Mr paul gatland
37 longships
beaumont park
LITTLEHAMPTON
BN17 6SL

Please ask for: Mrs D Johnson
Email: daun.johnson@arun.gov.uk
Telephone: 01903 737762
Our Ref: LU/50/21/PL
Your Ref:
Date: 25th February 2021

Application for Planning Permission

Development: Provision of 50 No. new beach huts on concrete bearers to broadly match existing.
This site is in CIL Zone 5 (Zero Rated) as other development.
Location: Littlehampton Promenade South Of Putting Green Sea Road Littlehampton

Block Plan (East Part). Scale 1:500 at A3
Arun District Council Beach Hut Application
Red rectangles represent proposed positions
February 2021

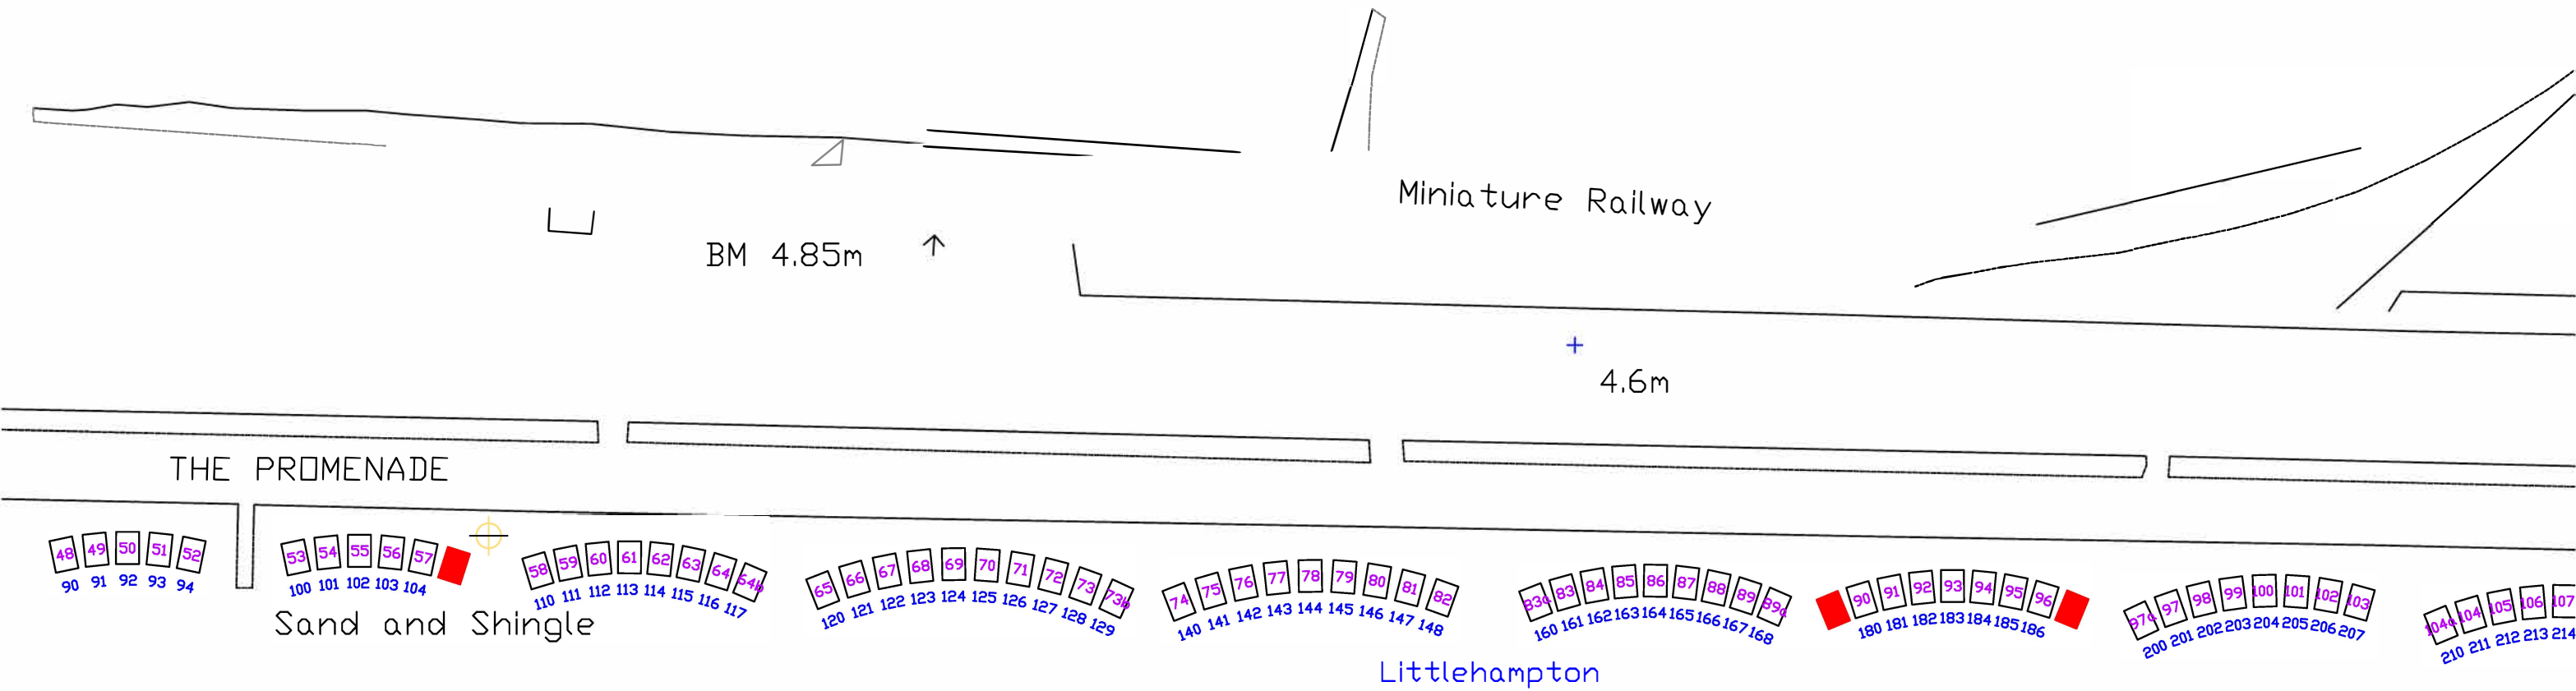
Block Plan

Please provide a North point on both block plans (East and West parts).

On the location and block plans, the plans indicate 20 No. beach huts while the application description says 'provision of 50 No. new beach huts...'. Please clarify if there are a total of 50 No. new beach huts (are all 50 beach huts being demolished and replaced) or a total of 20 No. beach huts are being demolished and replaced.

Floor Plan & Elevations. Scale 1:50@ A3
Arun District Council Beach Hut Application

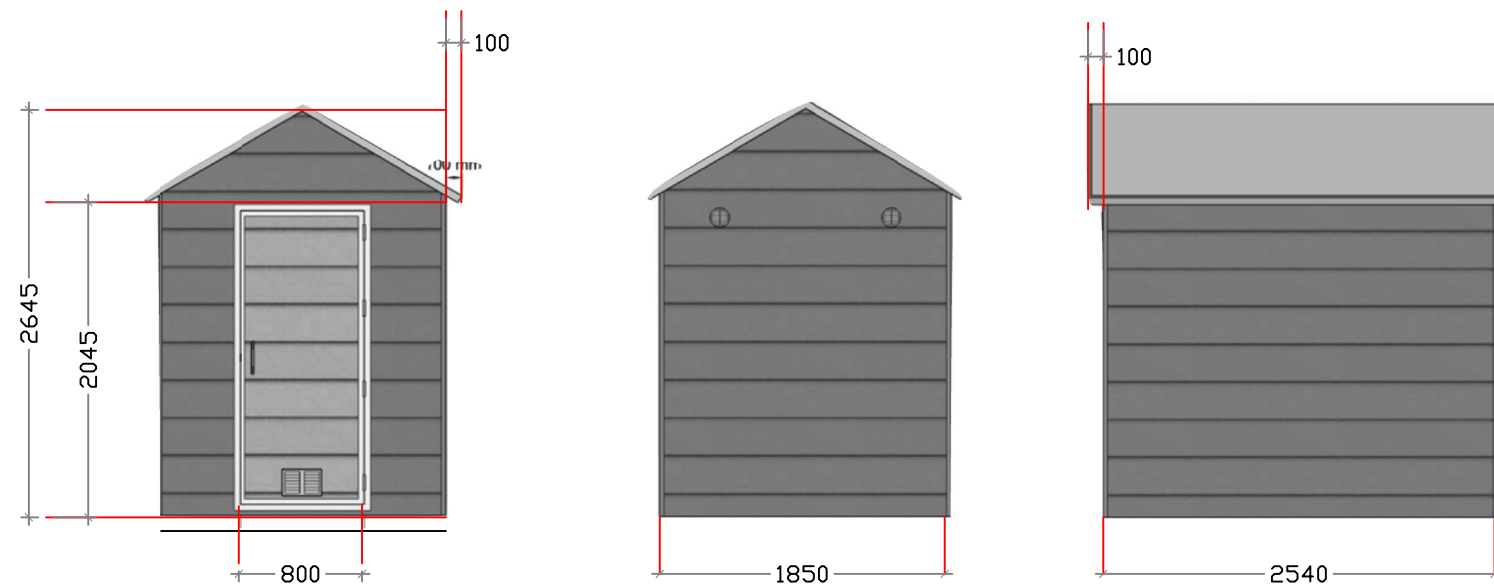
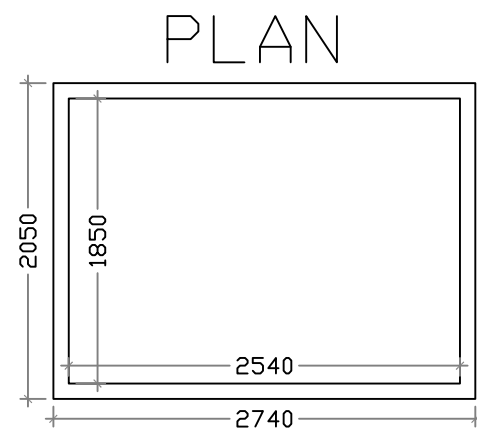
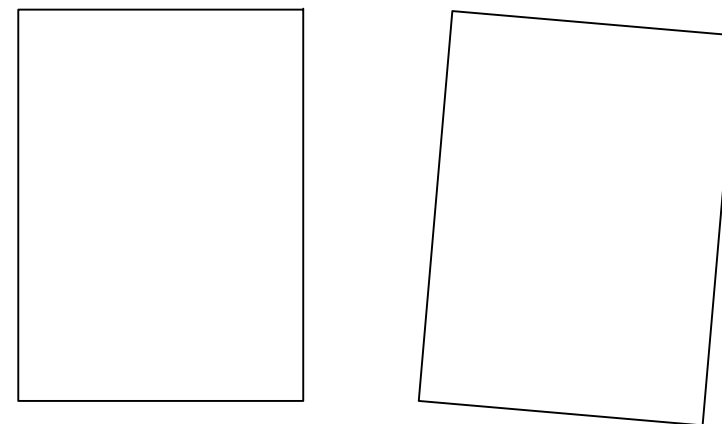
The proposed floor plan and elevations do not accord. Please amend accordingly.

Please provide the fourth elevation.

Please label the elevations as front, rear and as sides as applicable.
